Your ref:	Windows Opening/Double glazin...	Please reply to:	Mr Anthony Perera
Our ref:	24/02249/LBC	Tel No:	07866034072
		Fee Queries:	0207 641 6500;
		Email:	planningreception@westminster.gov.uk;
Mr Layth Tukmachi Flat 5, 75 Gloucester Terrace London W2 3DH United Kingdom		Incomplete Applications Town Planning & Building Control City of Westminster PO Box 732 Redhill, RH1 9FL	
		15 April 2024

Address: Flat 5, St James's Court, 75 Gloucester Terrace, London, W2 3DH,

Proposal: Removal and replacement of two new windows to match existing including creation of a second bedroom by creating a wall when the windows are opened.

**VIEWED FROM THE OUTSIDE**

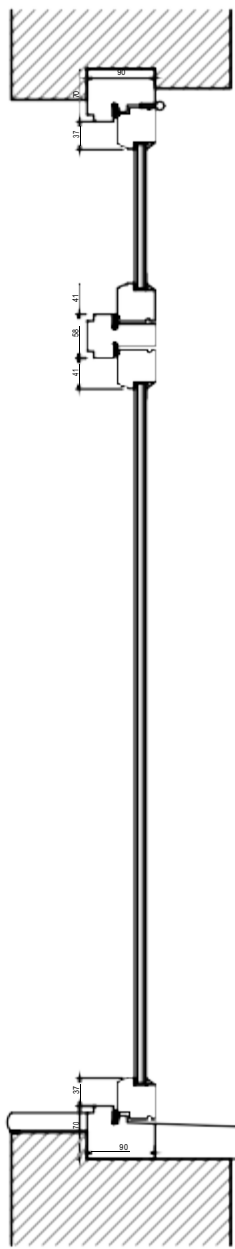
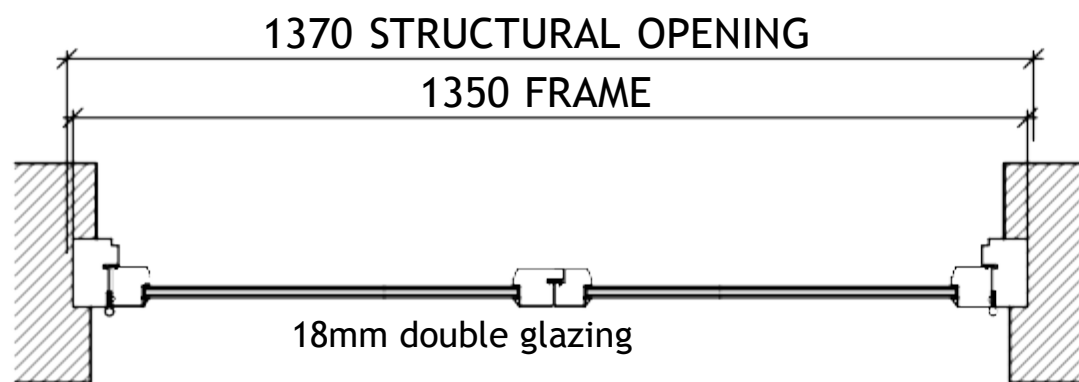
- 1 Please confirm if you are installing a new window, if so planning permission required, as your proposed drawings seem to show two new windows.
- 2 You need to submit an application for Planning Permission. The application should be submitted through the planning portal <https://www.planningportal.co.uk/applications>
